# KITTITAS COUNTY FIRE MARSHAL'S OFFICE

Fire Marshal comments  
Pfenning Road  
LP-25-00004

Zach Torrance-Smith, Project Planner

SHEET NAME
PRELIMINARY PLAT

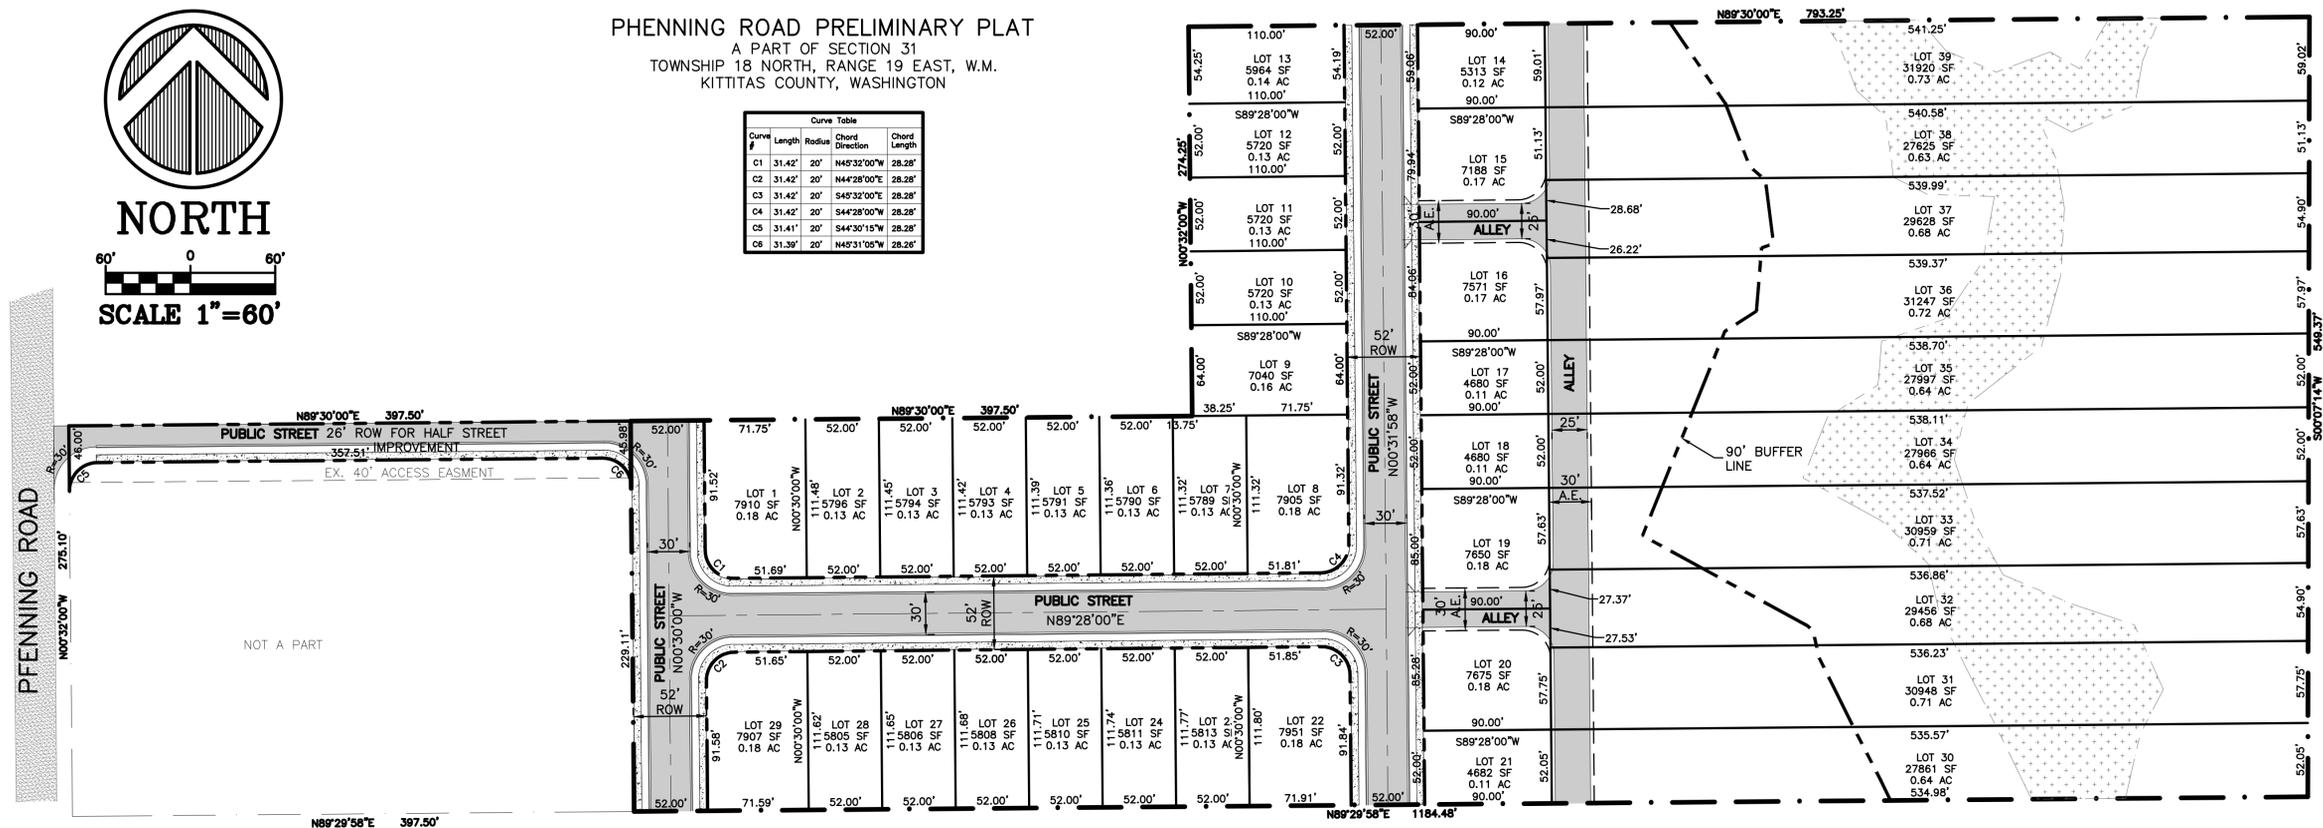
Fire hydrants are required for this application. Either the indicated number or the spacing of the fire hydrants is inadequate. Provide fire hydrants such that the maximum spacing between hydrants does not exceed 500 feet and such that no lot or parcel is in excess of 250 feet from a fire hydrant as measured along approved fire apparatus access roads.

Approved fire apparatus turnarounds are required for this project. The indicated provisions for turning around fire apparatus are adequate.

Developments exceeding 30 lots shall be provided with two separate and approved fire apparatus access roads. There are exceptions to this code section that can be discussed.
